# SADDLEHORN RANCH - FILING NO. 2

EPC STORMWATER REVIEW COMMENTS ARE SHOWN IN ORANGE BOXES WITH BLACK TEXT

## PRE-DEVELOPMENT GRADING AND EROSION CONTROL PLANS

PCD FILE NO. EGP221

SHEET 7 OF 14  
JOB NO. 2514204

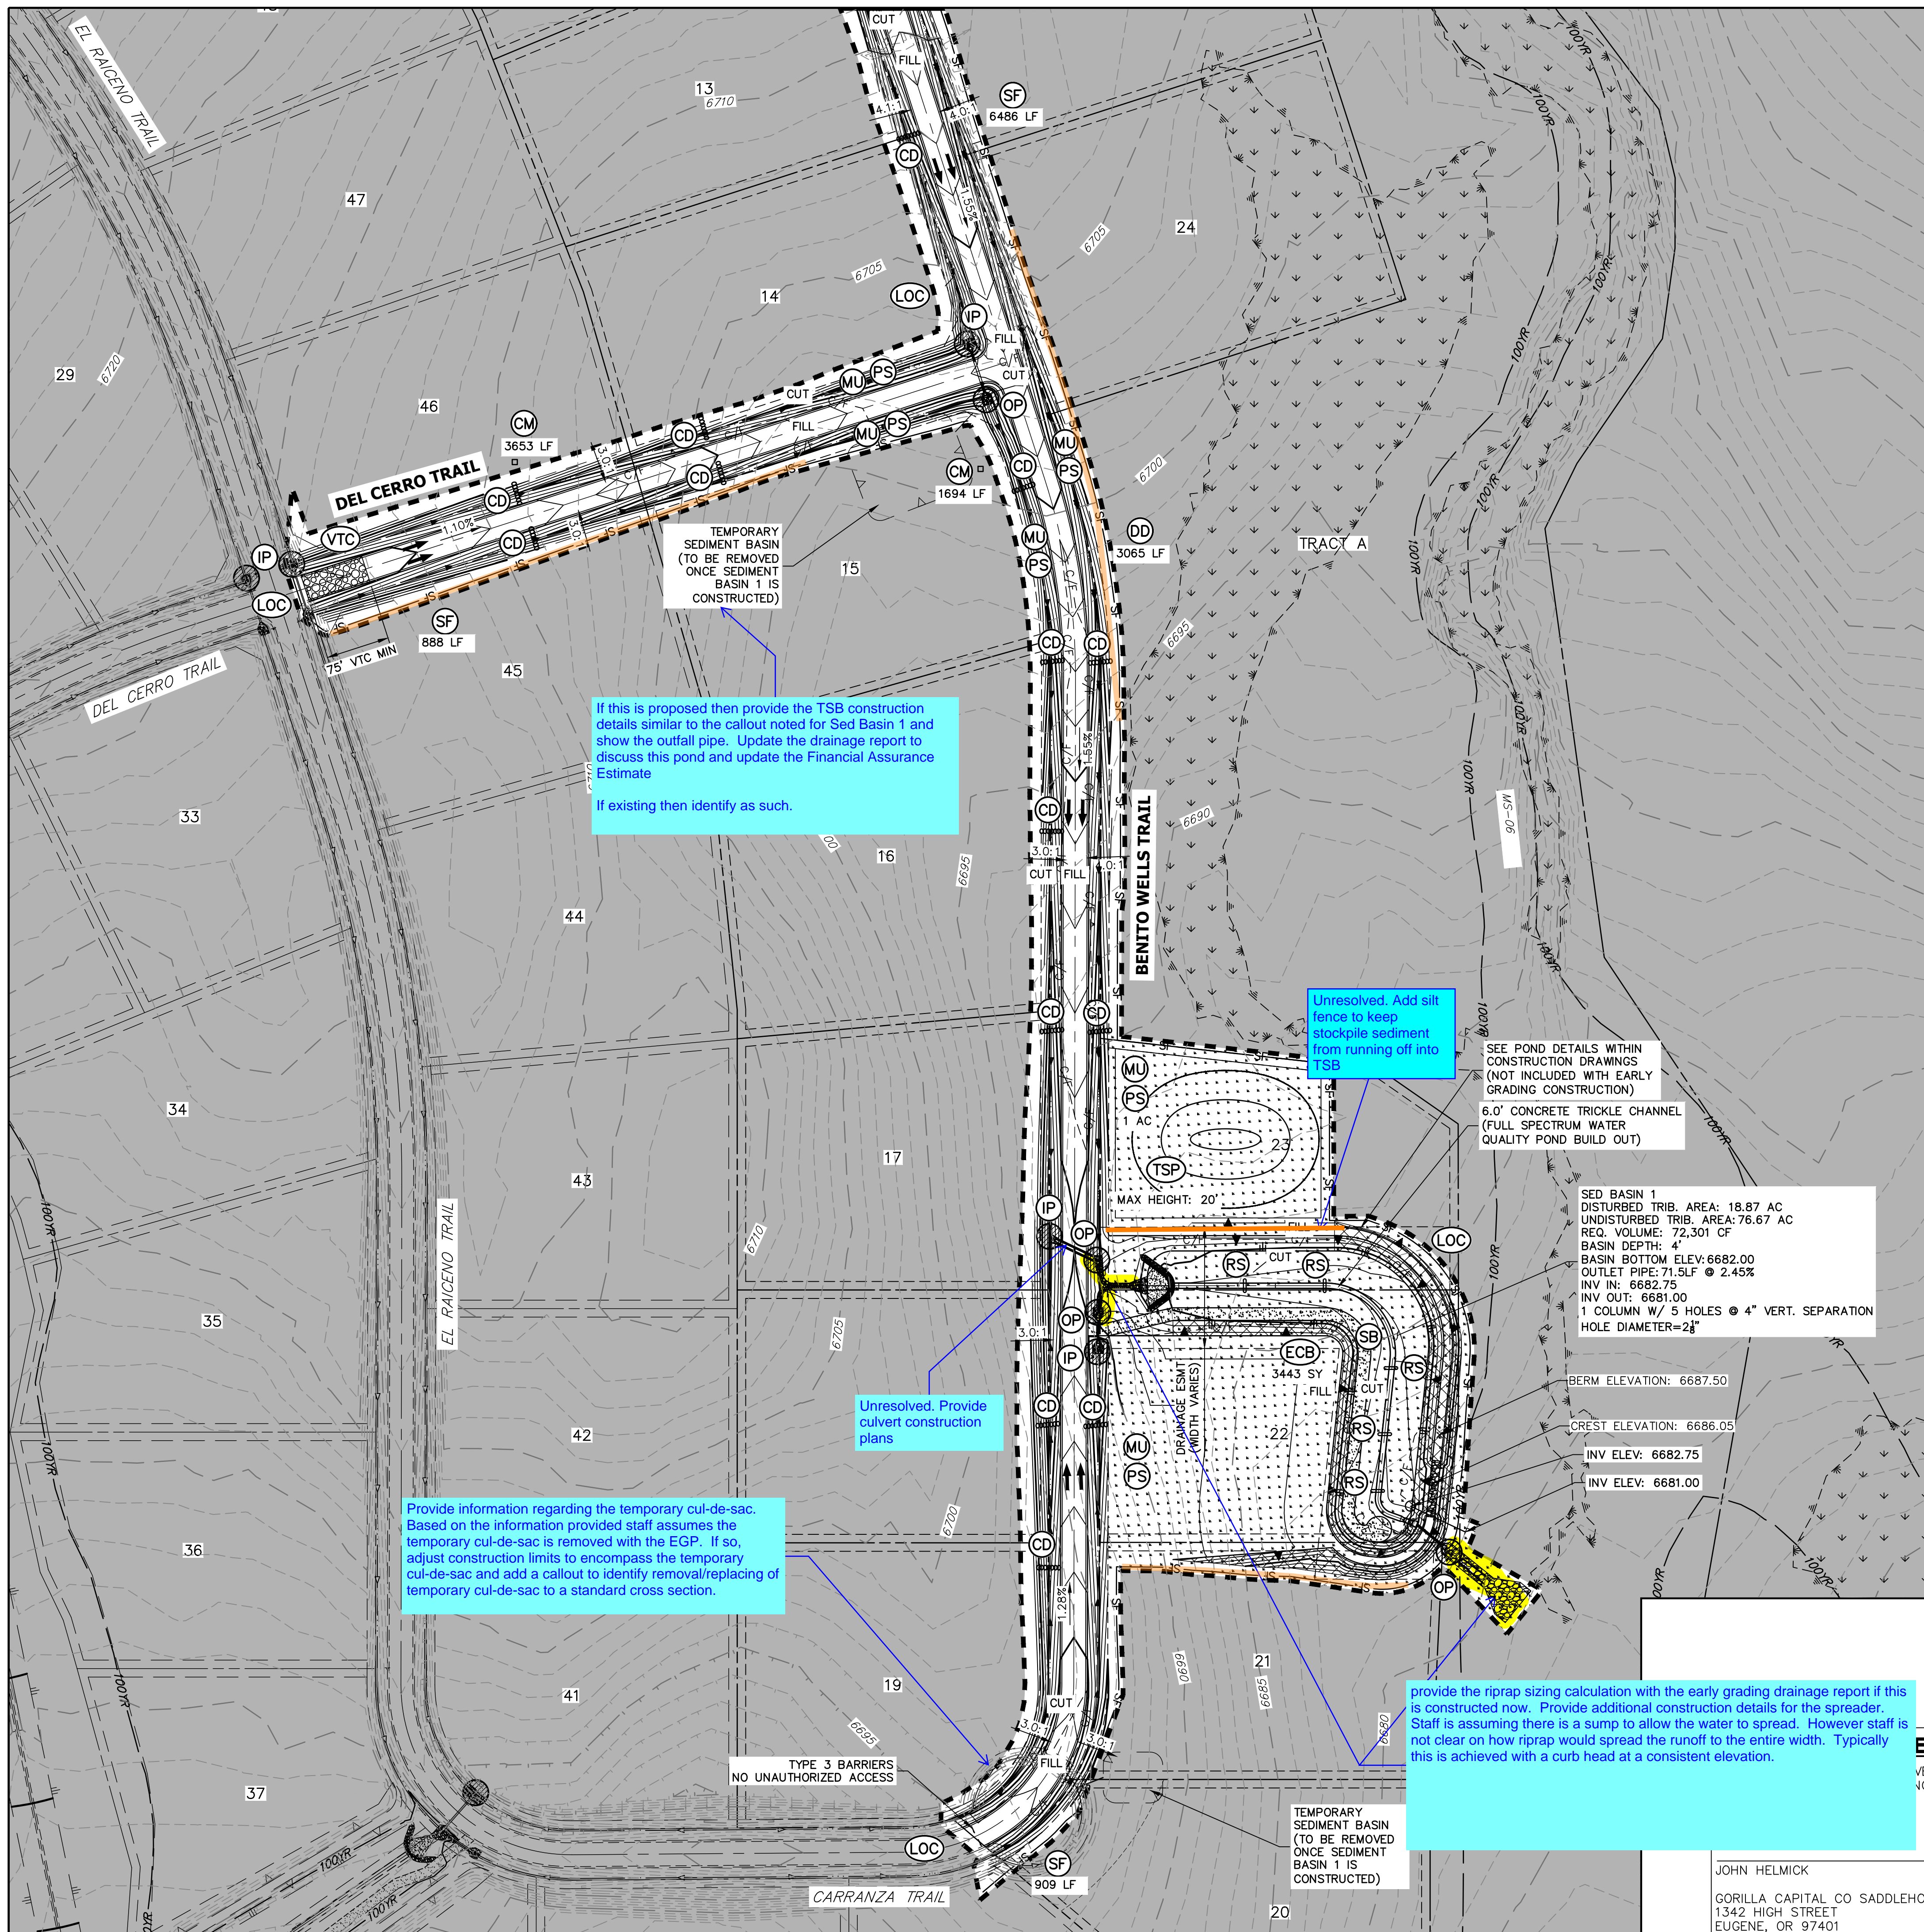
If this is proposed then provide the TSB construction details similar to the callout noted for Sed Basin 1 and show the outfall pipe. Update the drainage report to discuss this pond and update the Financial Assurance Estimate

If existing then identify as such.

Unresolved. Add silt fence to keep stockpile sediment from running off into TSB

Unresolved. Provide culvert construction plans

JR: This temporary sediment basin was constructed with the previous phase making it existing. The label has been updated to reflect that.

JR: See label on page 4.1. Inverts, slope, cover, and distance between the culverts has been added. Per conversation with Elizabeth.
